Maules Creek Coal Mine

Employee Transport Modification Responses to Submissions

AUGUST 2016
Project No. WHC-15-30
Document No. 00756930.docx

Figure 1. MOD 3 EA. Note the S-W direction of the Mine Access Road and the railway where the biodiversity corridor is supposed to be link between the Leard State Forest and the Pilliga Forests.

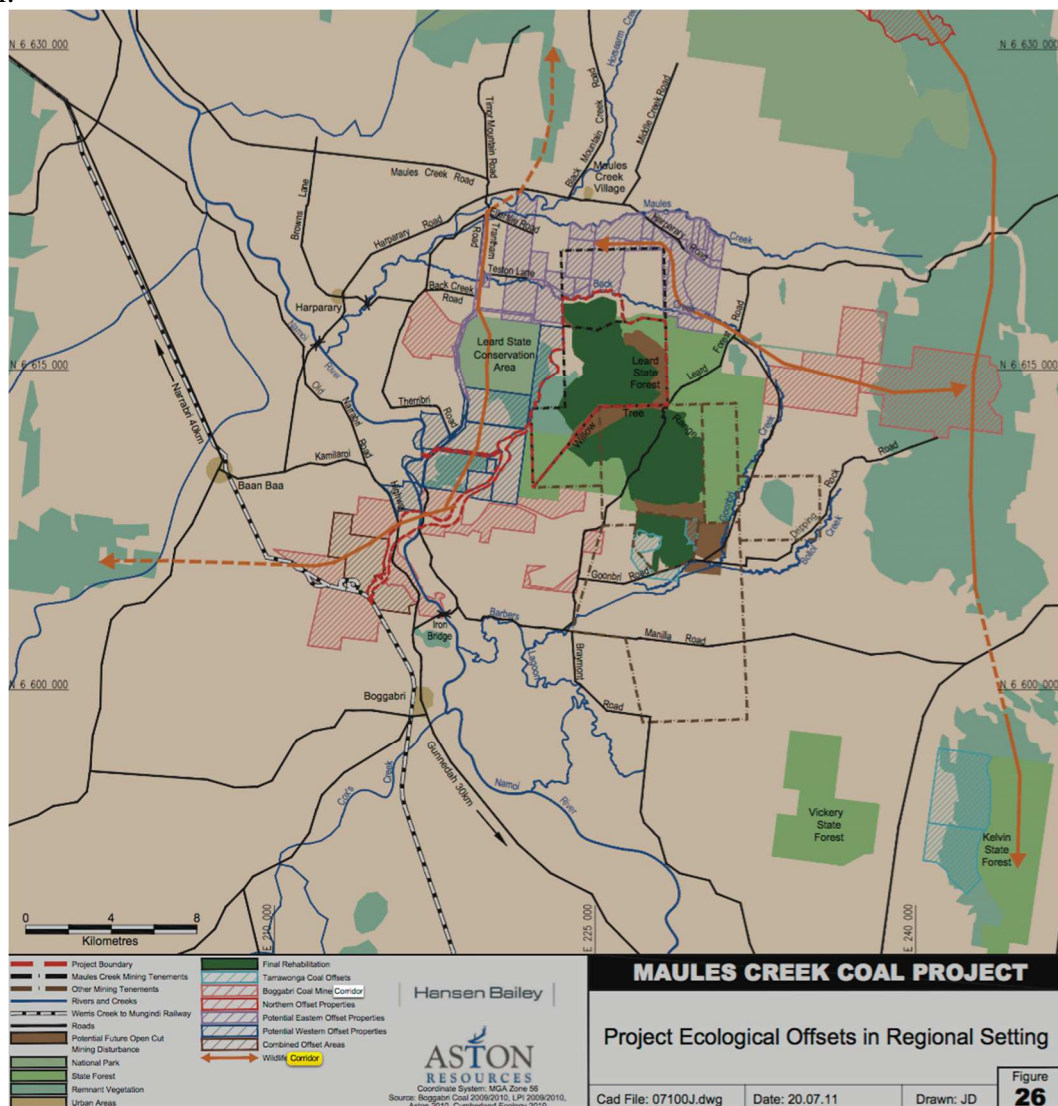
Issue ID Number	Subject	Issue Raised	Response
1	Legislative Requirements	Concern was raised regarding whether Section 79C of the EP&A Act is appropriately addressed in the Modification.	Although Part 3A of the EP&A Act was repealed on 11 October 2011, the Maules Creek Coal Project remains a “transitional Part 3A project” under Schedule 6A of the EP&A Act. The proposed Modification is therefore being considered under Section 75W of the EP&A Act, in accordance with the relevant savings provisions.
2	Proposed Wording Of Condition 63	Concerned was raised regarding the proposed revised wording of Condition 63.	This is addressed in Section 2.1.
3	Biodiversity	Concern was raised regarding the potential for the Modification to impact on previously identified biodiversity corridors. In particular, these submissions suggest that the Modification would increase road transport movements which would in turn result in additional incidents of vehicular fauna strike along the Maules Creek Coal Mine access road. The issues raised include discussion of the Maules Creek Coal Mine access road traversing an east-west biodiversity corridor, leading to potential for vehicular fauna strike.	It should be noted that the approved <i>MCCM Revised NSW Biodiversity Offset Strategy</i> (Whitehaven, 2015) (endorsed by OEH) identified that the east-west biodiversity corridor is located to the west of the Maules Creek access road; hence it is an incorrect assertion that the access road traverses the approved east-west biodiversity corridor (Plate 1).
